Appeal Decision

Appeal Ref: APP/R5510/W/25/3369226

15 Manor Road, Ruislip, Hillingdon HA4 7LA

- The appeal is made under section 78 of the Town and Country Planning Act 1990 (as amended) against a failure to give notice within the prescribed period of a decision on an application for planning permission
- The appeal is made by Mr and Mrs Leslie against the Council of the London Borough of Hillingdon.
- The application Ref is 29504/APP/2025/313.
- The development proposed is a two-storey side and rear extension.

PROPOSED GROUND FLOOR PLAN

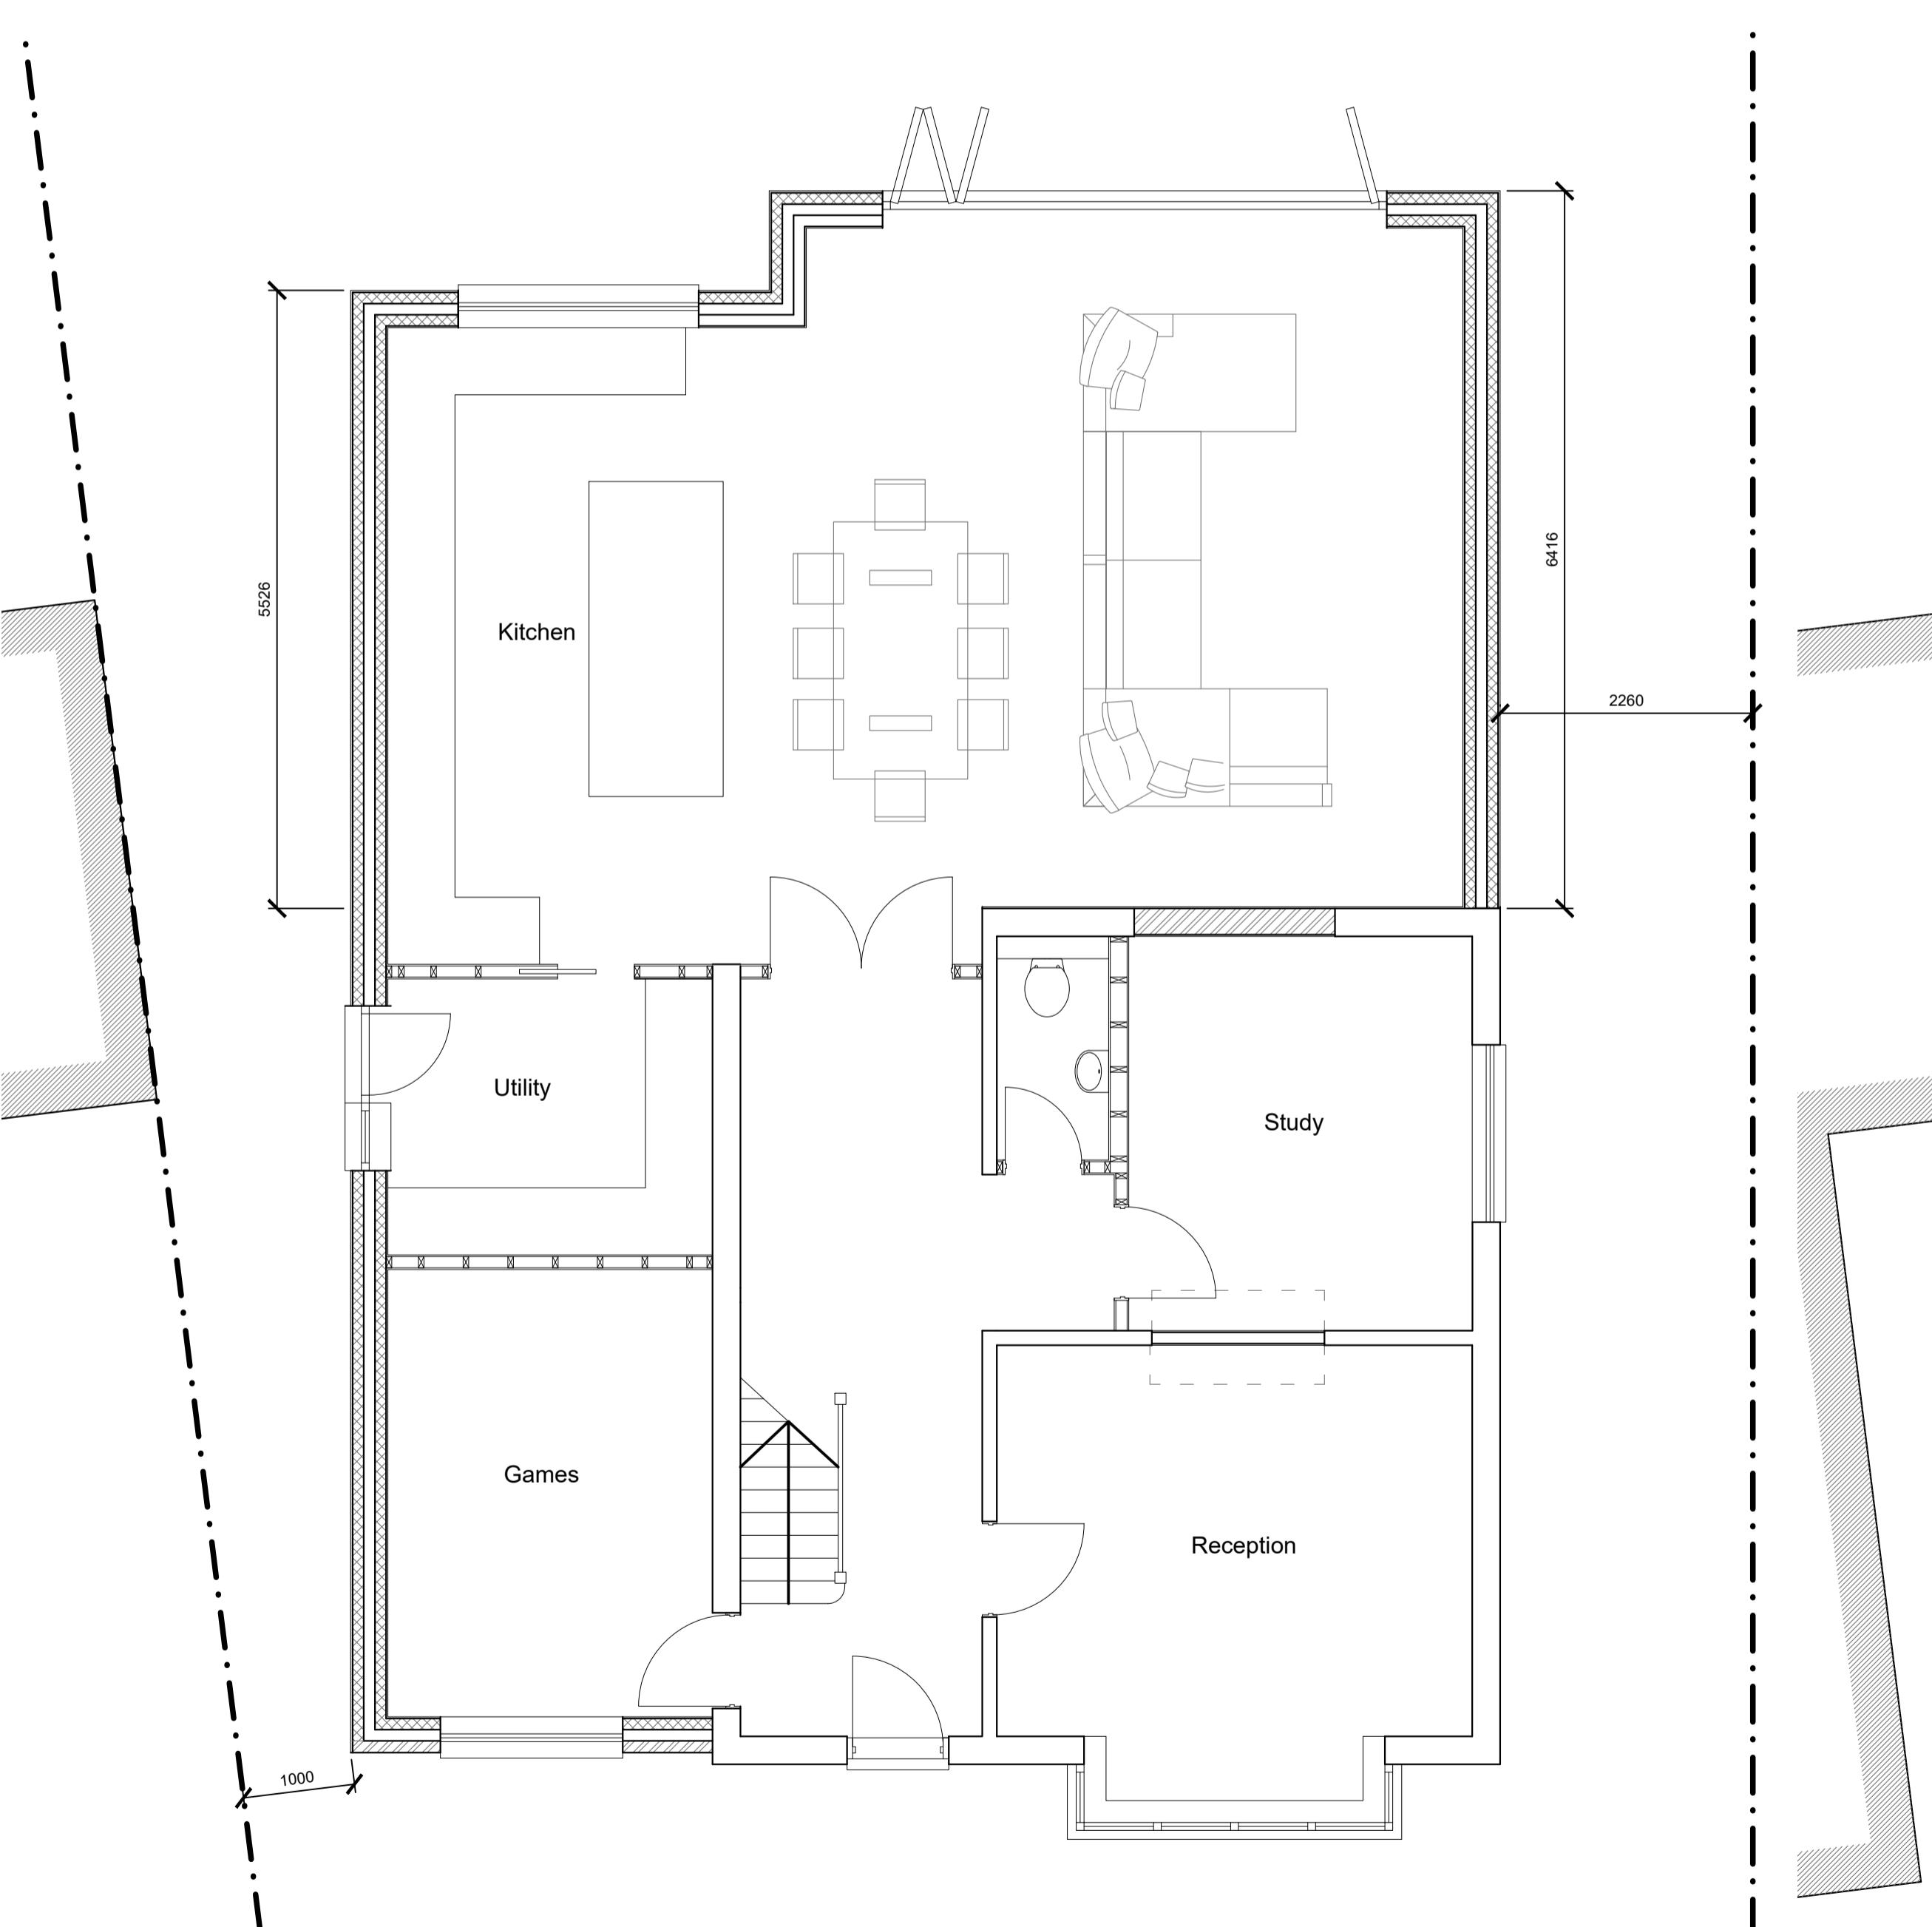
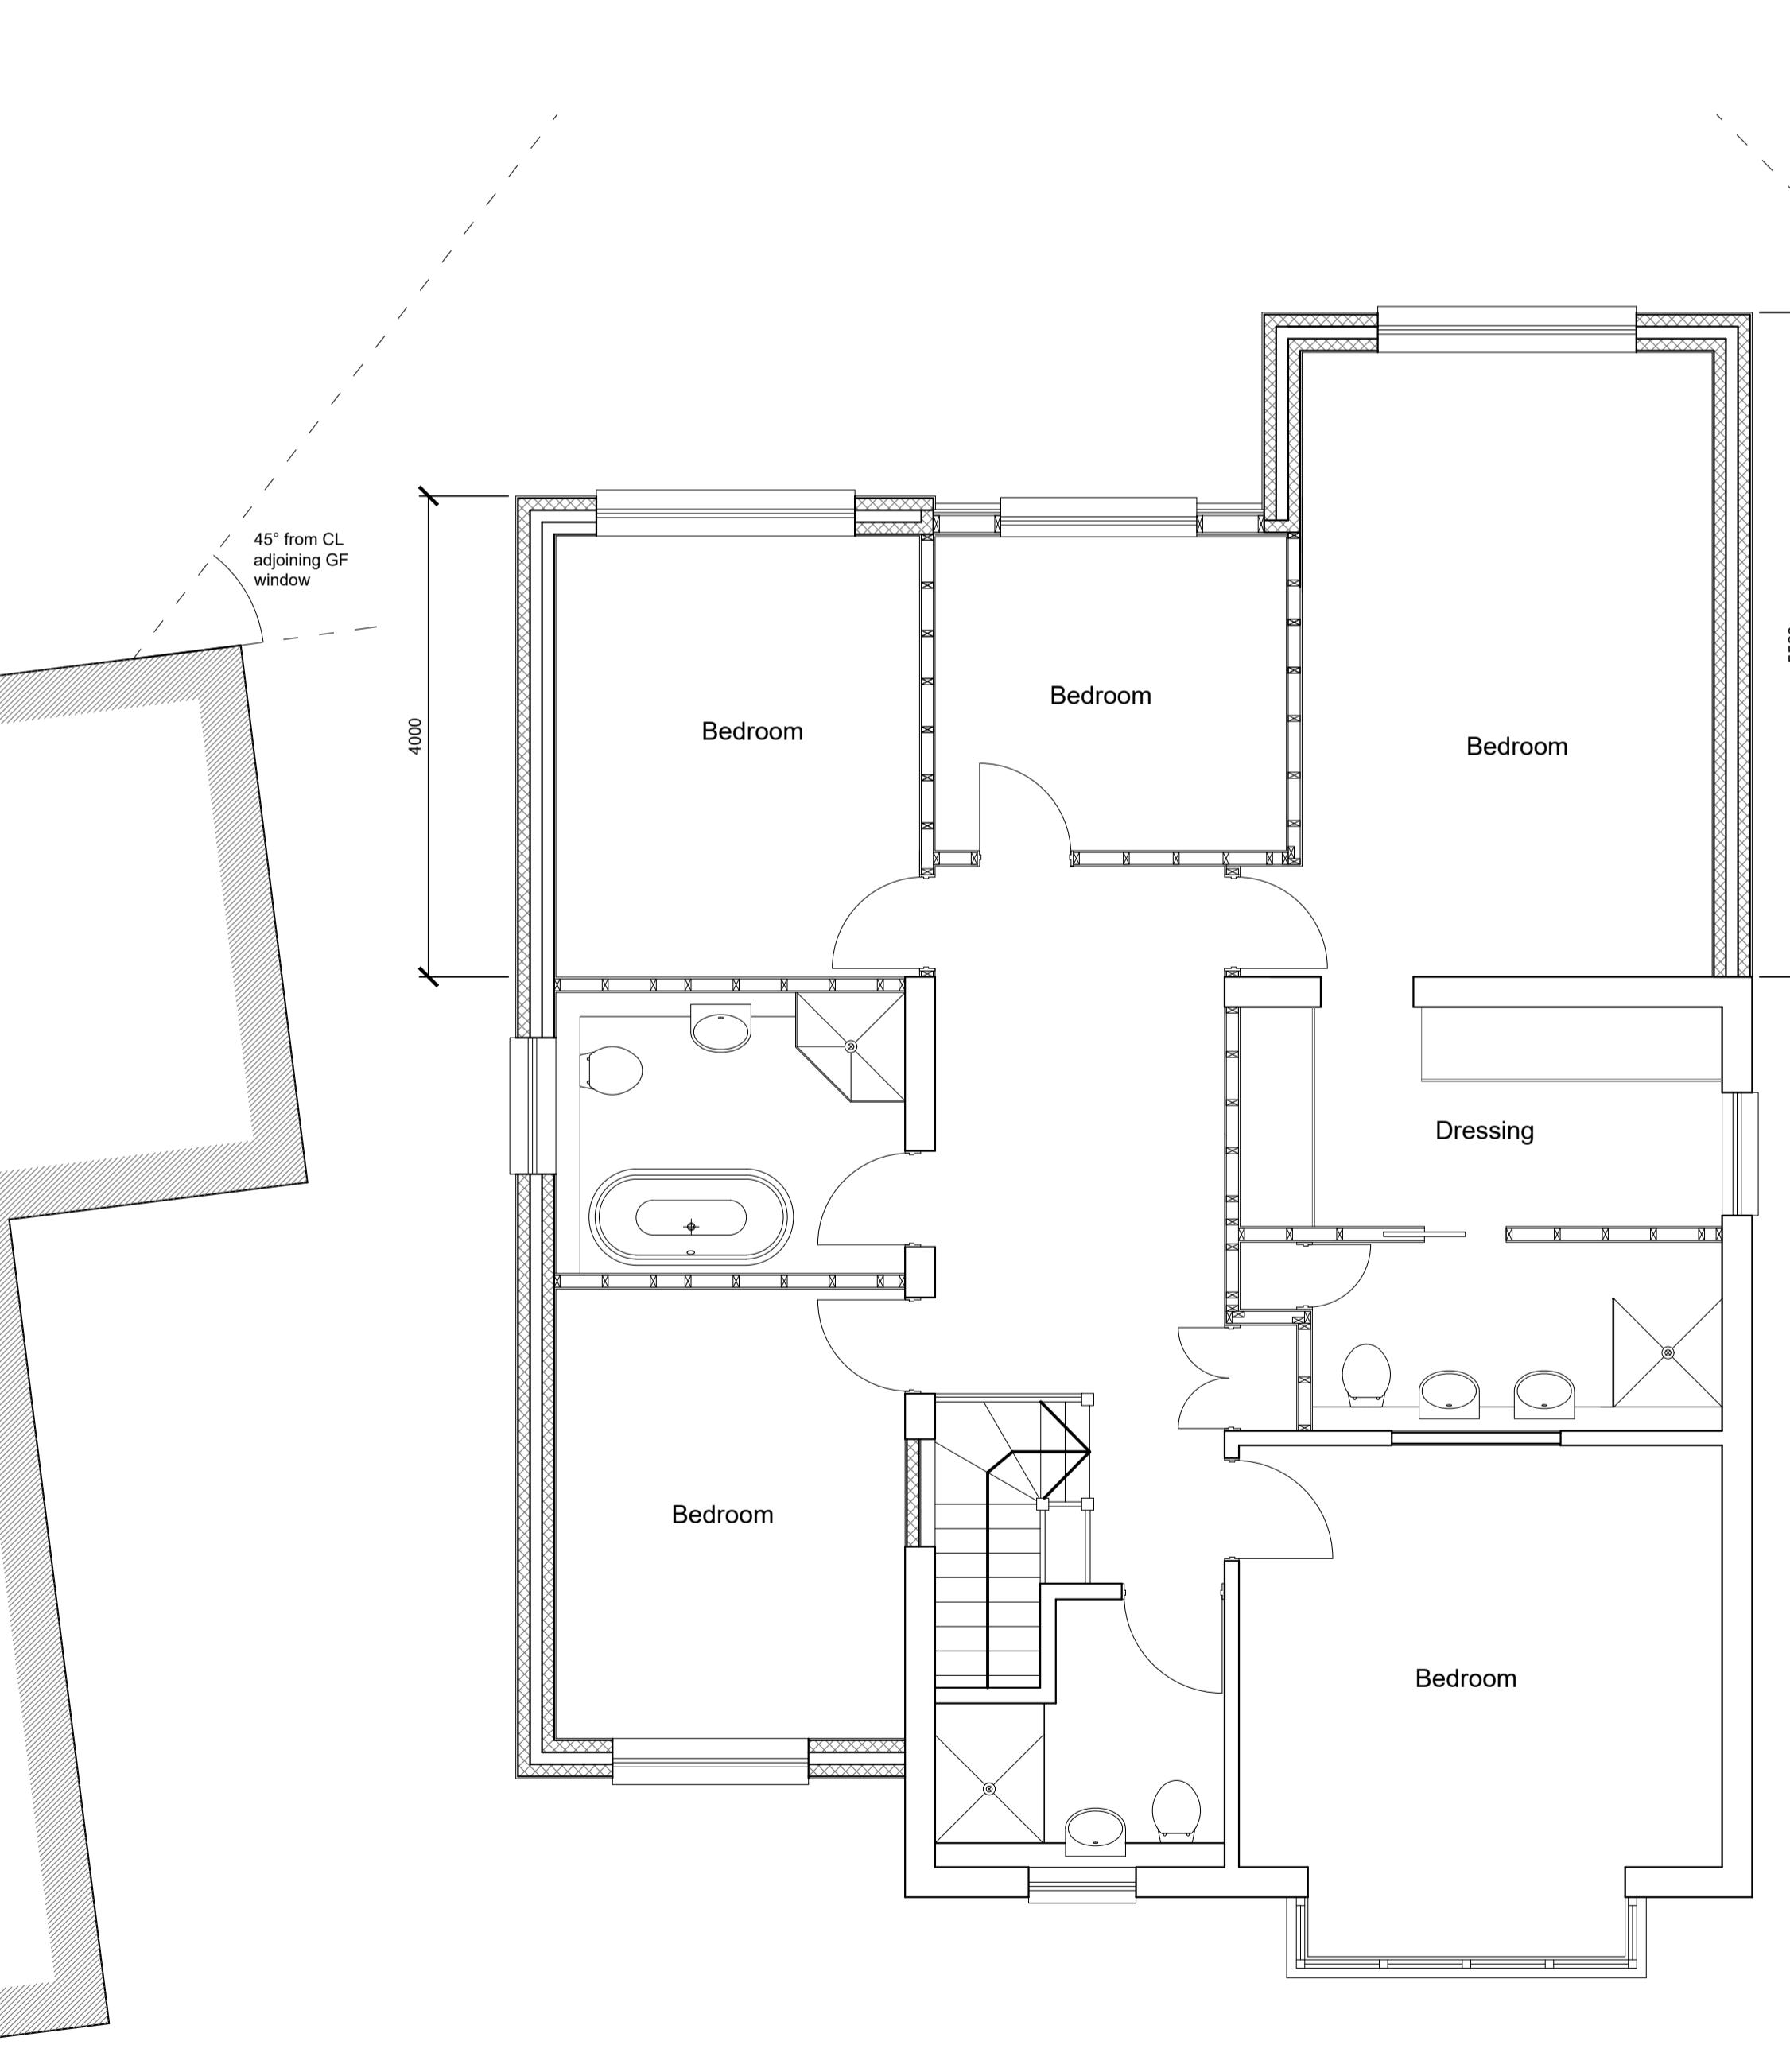
5. The appeal proposal would involve a significant side and rear extension which would wrap around and entirely subsume the existing building and harmfully erode its simple plan form. Moreover, the combination of different rooflines and asymmetry would result in awkward intersections, particularly at the rear, detracting from not only the gable feature on the front of the building but similar ones in the street. There would be some appearance of subservience from the front elevation, however, the overall combination of extensions would be large and clearly not

6. Policy DMHD 1 details how alterations and extensions should relate to dwellings. Single storey extensions should not exceed 4m in depth, however, the proposal at single storey level exceeds this figure. Whilst the additional storey would meet this requirement, it would not result in an acceptable scheme overall. Resultantly, it would subsume the rear elevation and present an incongruous and large extension, leading to the above harmful effects. Whilst the render proposed would not be rough, subject to an appropriate coloured finish and the degree of variance in this respect locally, a smoother finish would not be harmful in and of itself.
